SUPPLEMENTAL PLANNING STATEMENT IN RESPECT OF
OF A DETAILED PLANNING APPLICATION FOR THE ERECTION OF AN AGRICULTURAL BARN
ON LAND OFF CARR HEAD ROAD, HOWBROOK AND TO THE NORTH OF HOLLINBERRY LANE,
HOWBROOK, WORTLEY, SHEFFIELD.,
for MR S WRAGG

In response to several question raised by the planning department, in relation to this application, please see below.

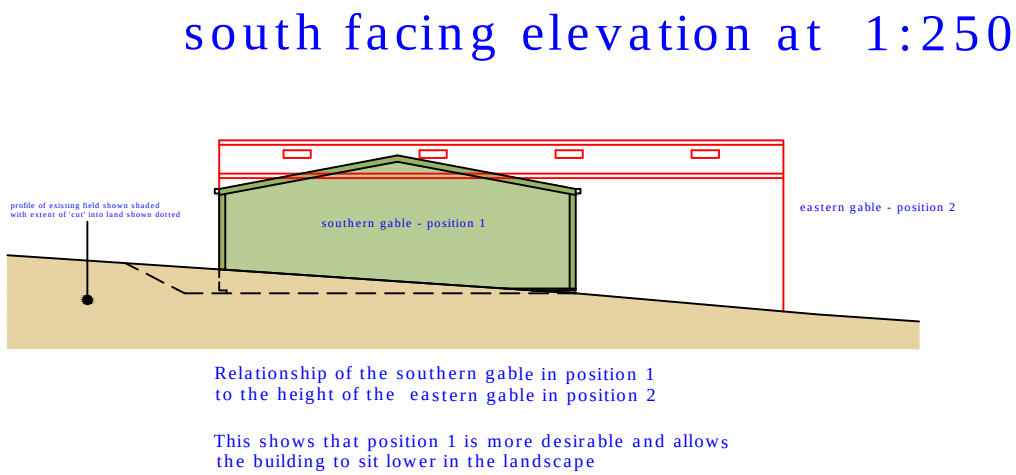
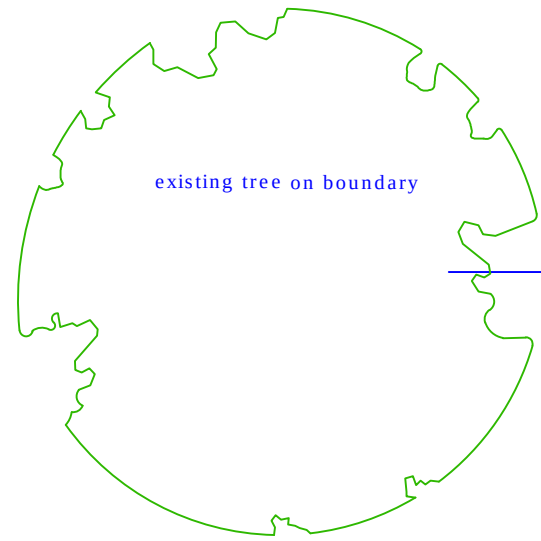
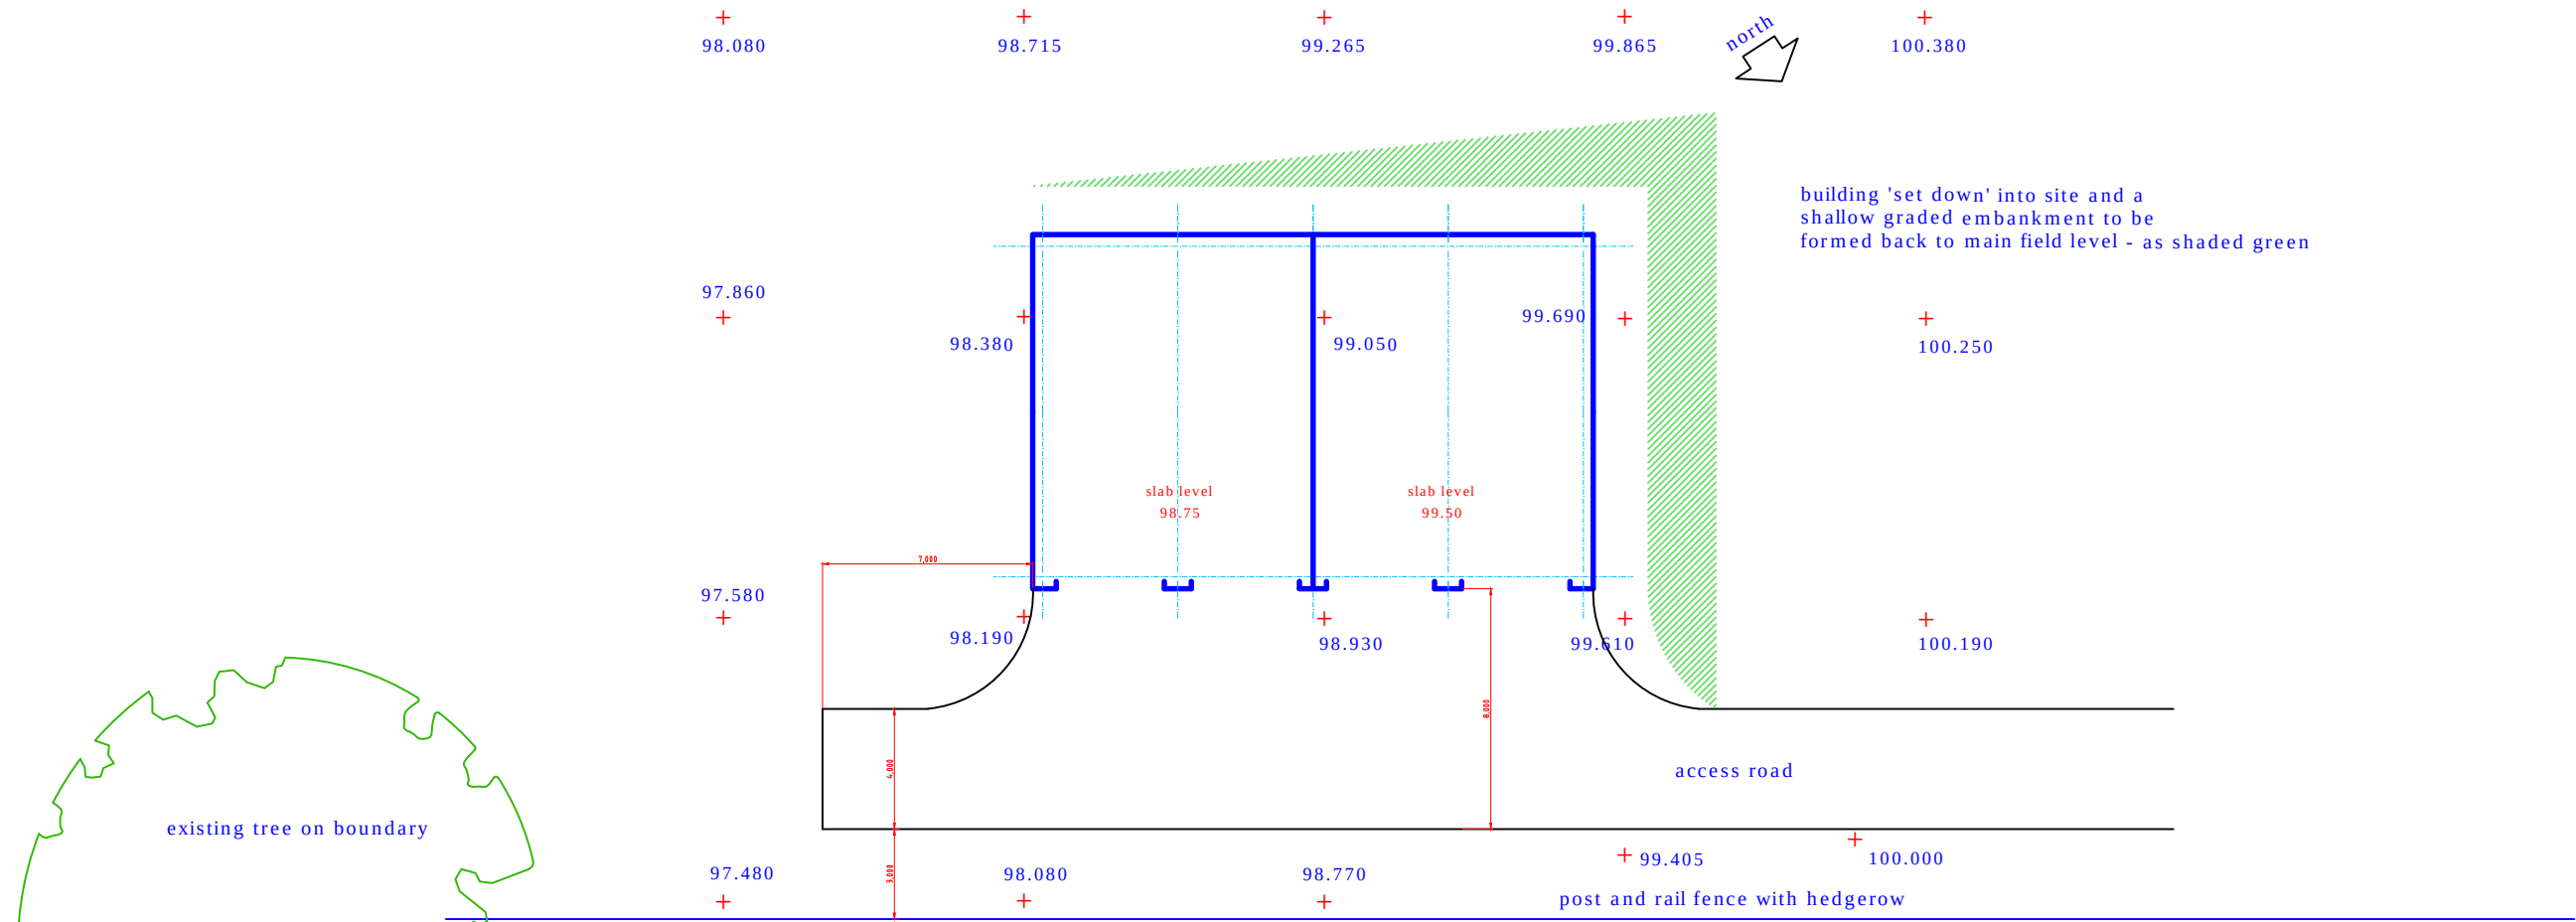
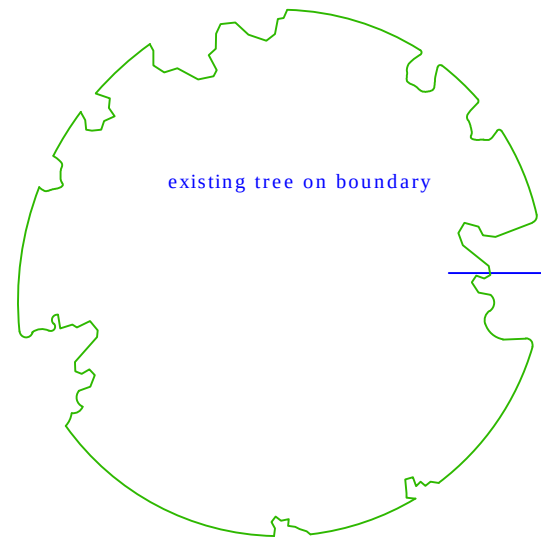
Secondly to deal with the position of the barn and the site levels :

It is a fact that the field in question does have a slope and we have taken site levels to show the extent of the level changes.

We have taken the opportunity of re-visiting the proposed position of the barn on the basis of these levels and the amended drawings re-submitted alongside this planning statement explain the situation.

The barn will be 'set down' into the site and so the extent of visible elevations will to some degree be less than we were showing on the original elevations.

In fact from a practical point of view it would be better for the barn to be turned through 90 degrees (as shown in position 1). This allows a more practical solution for maintaining a level floor across each opening with the least amount of 'cut' into the site.

Another benefit of altering the building's alignment results in the doors and open frontages being more protected from prevailing weather and thus creating a more comfortable environment for the animals.

It is of course possible for the building to be aligned as originally proposed, but on balance it is our view that this would be less practical than position 1.

It is generally agreed that position 1 is better and so the elevation drawing reflects the appropriate ground levels accordingly.

DRAWING
Barn details - plan, section and elevations

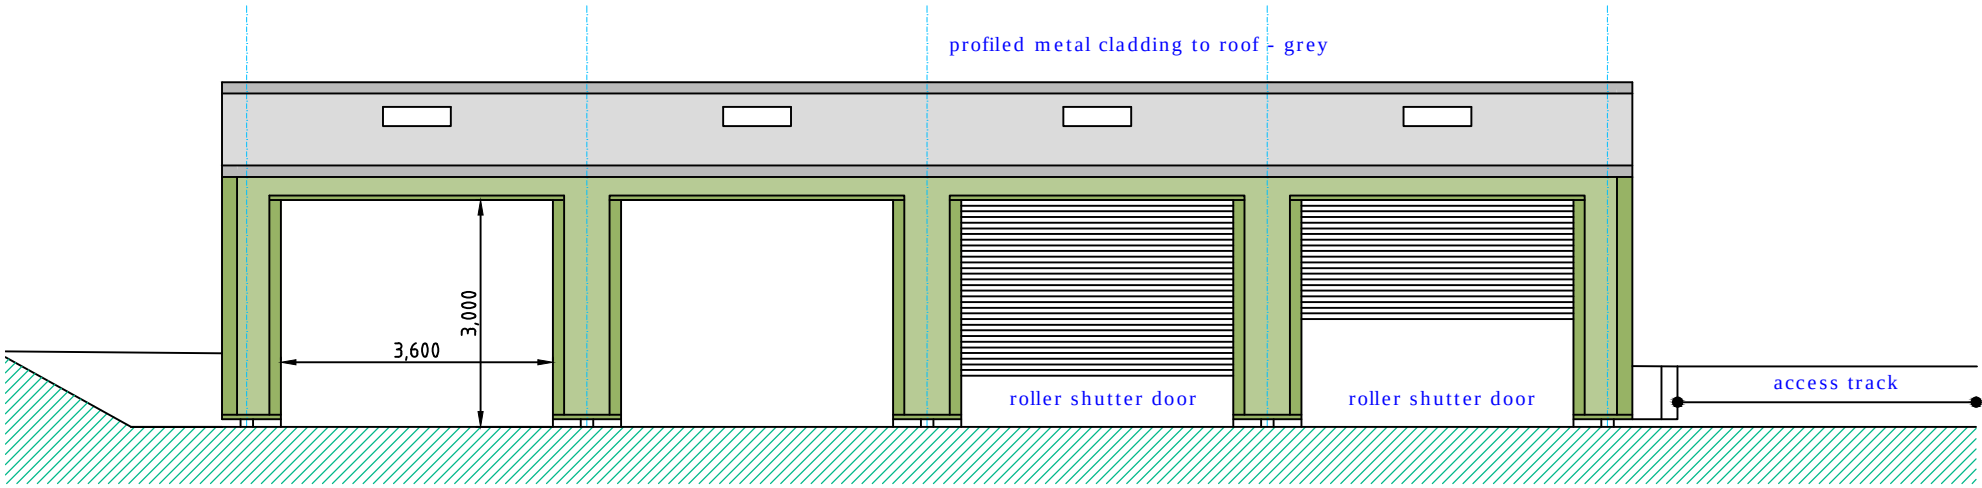
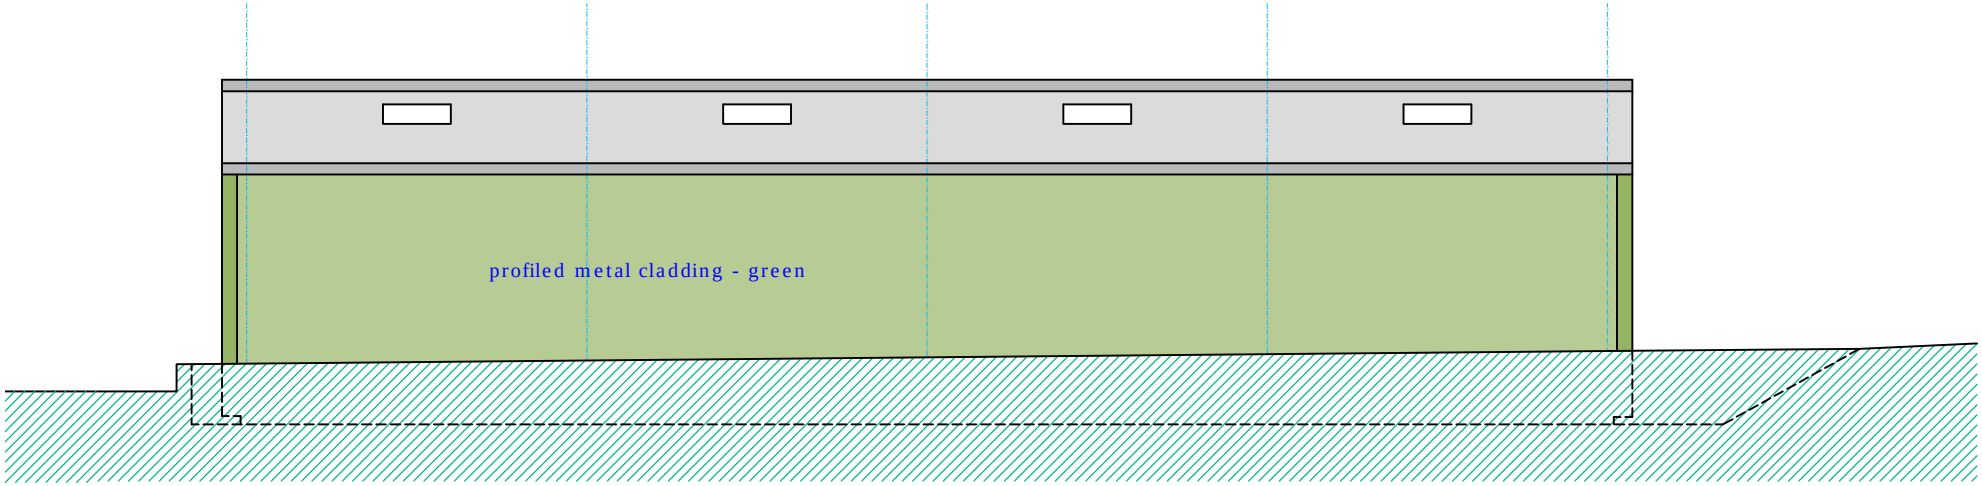
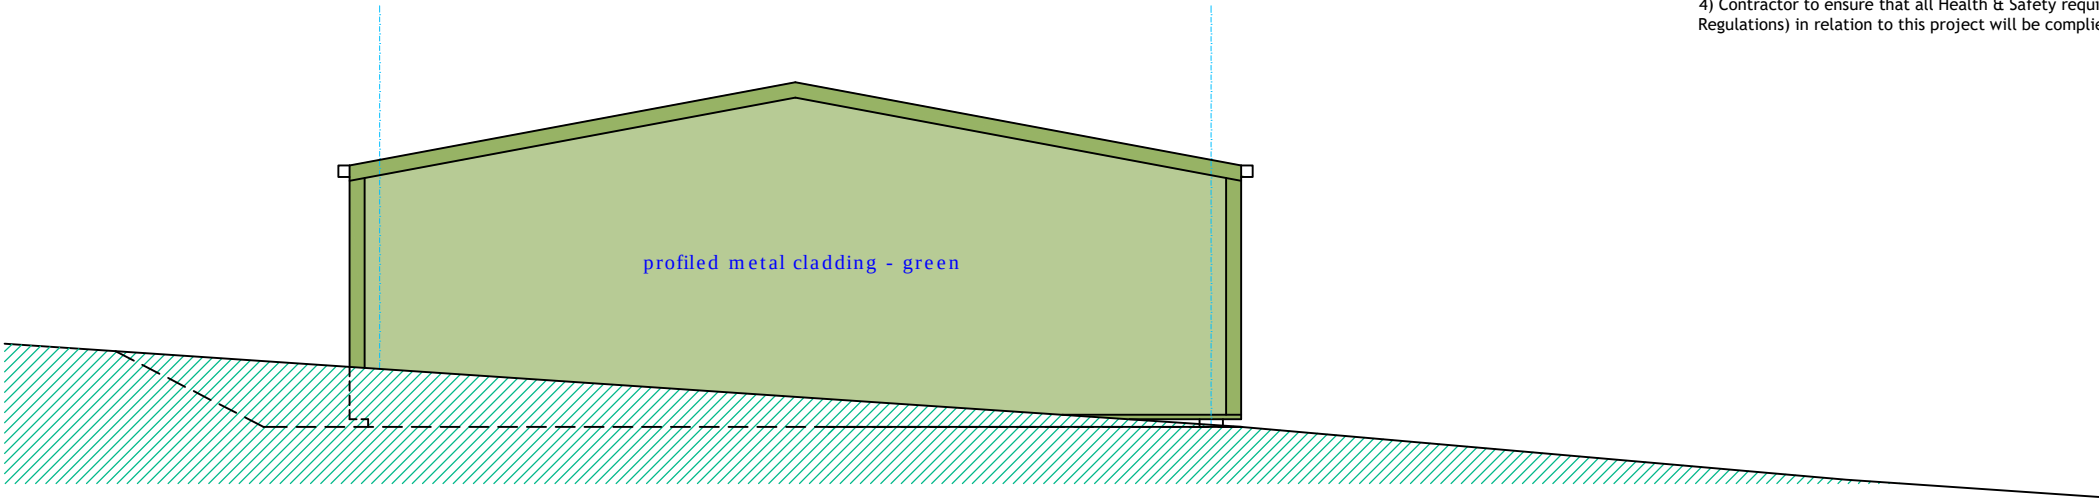
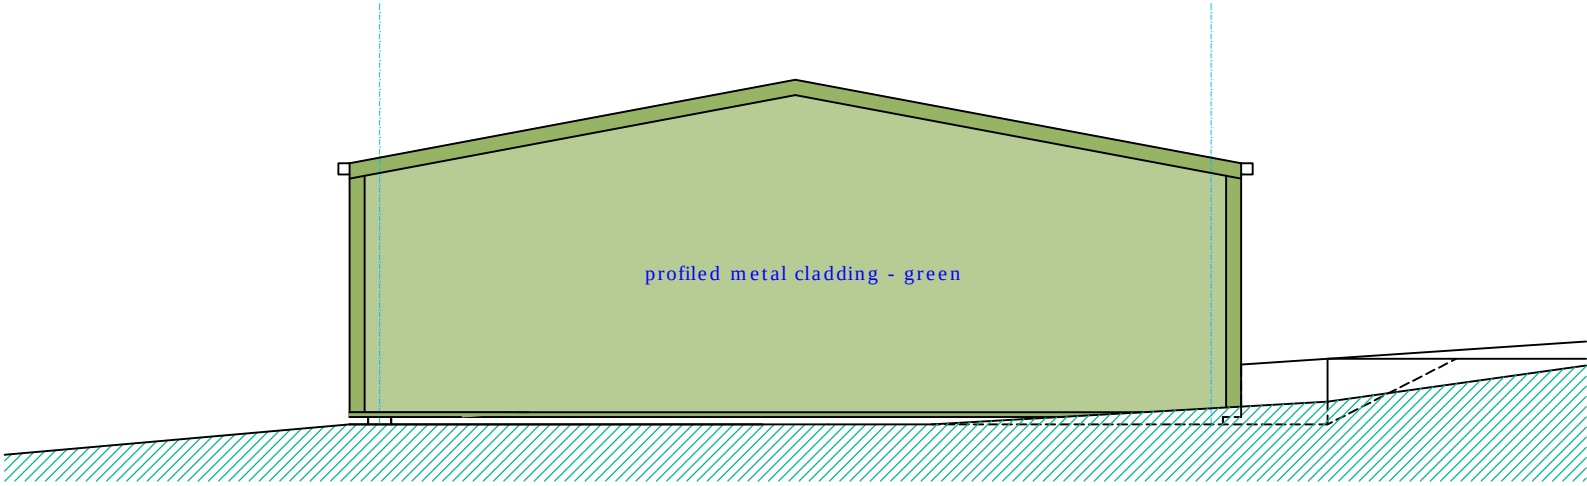
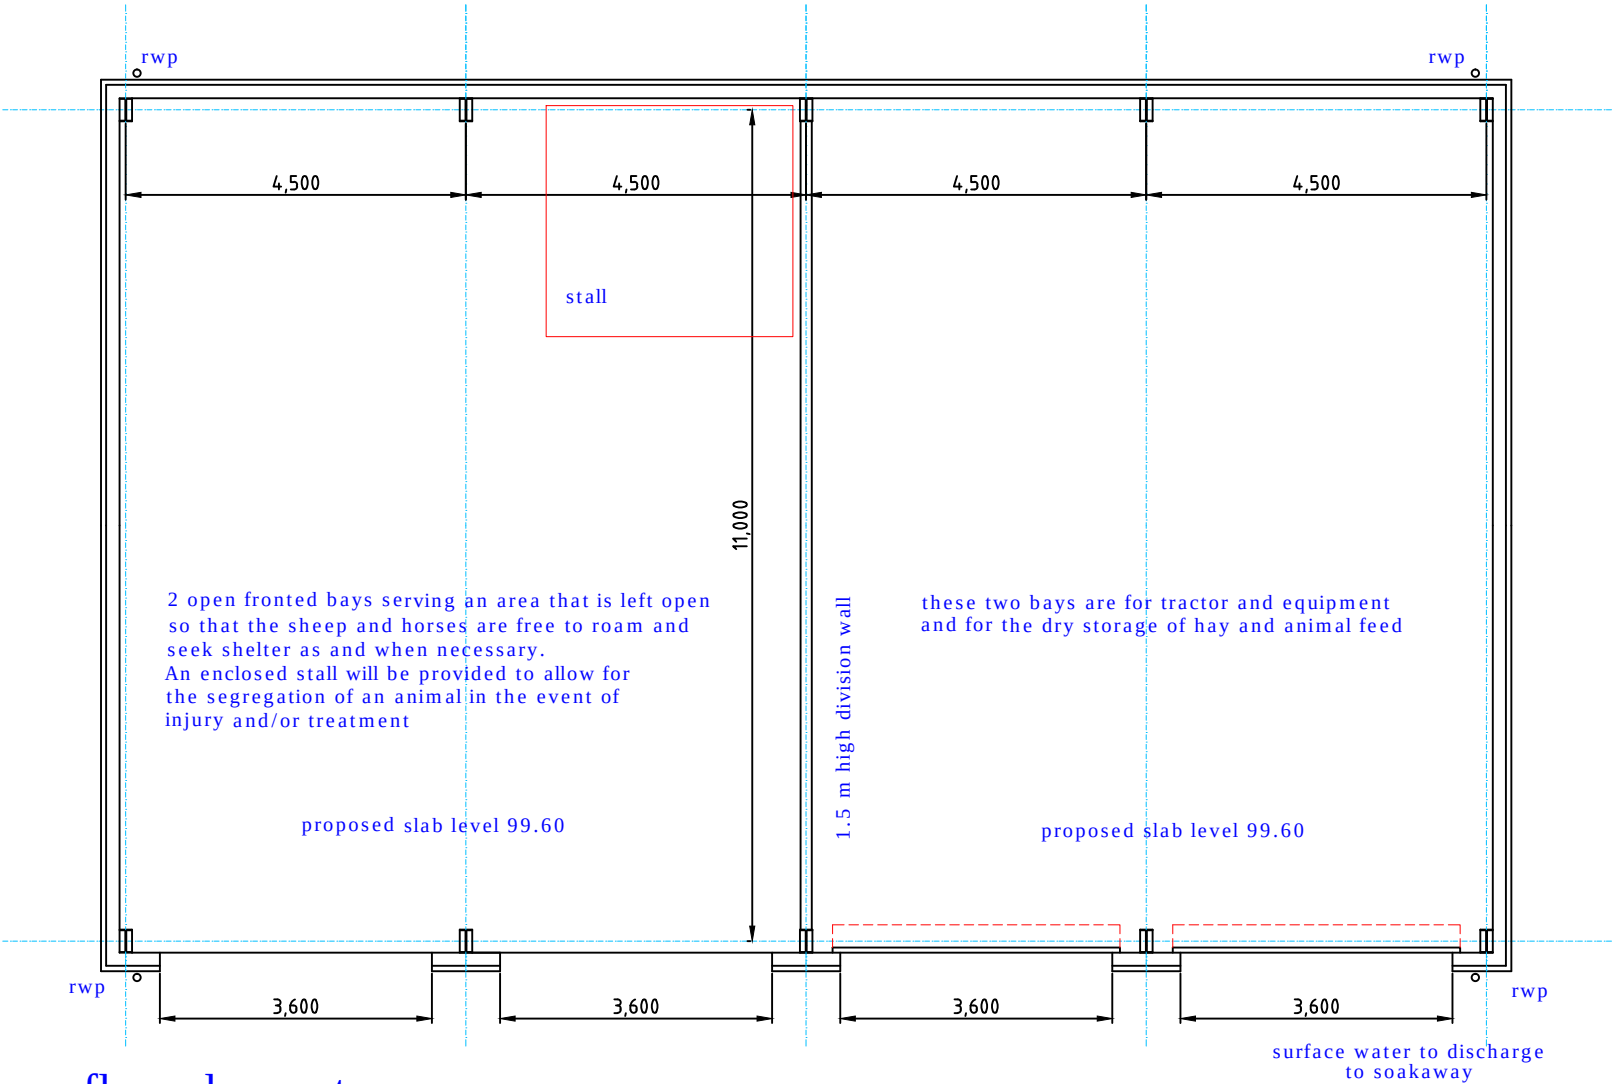
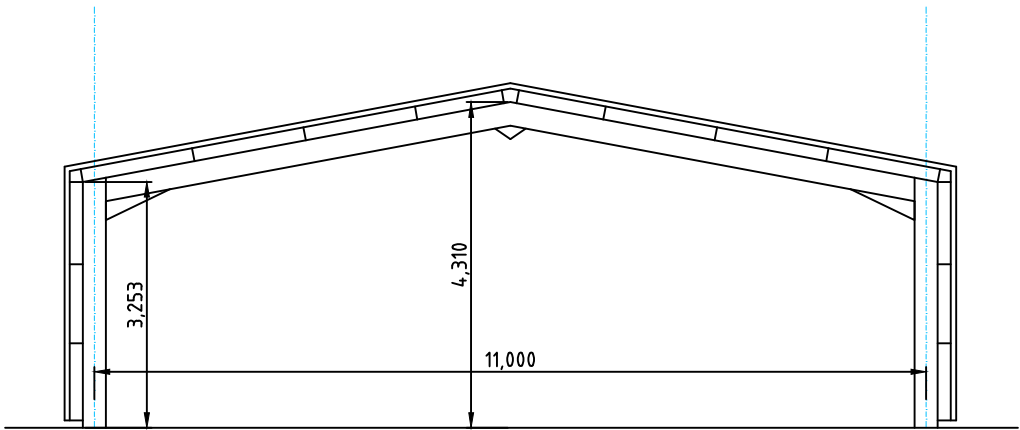
Thirdly to deal with the barn internal layout :

Please see the amended barn layout drawing attached.
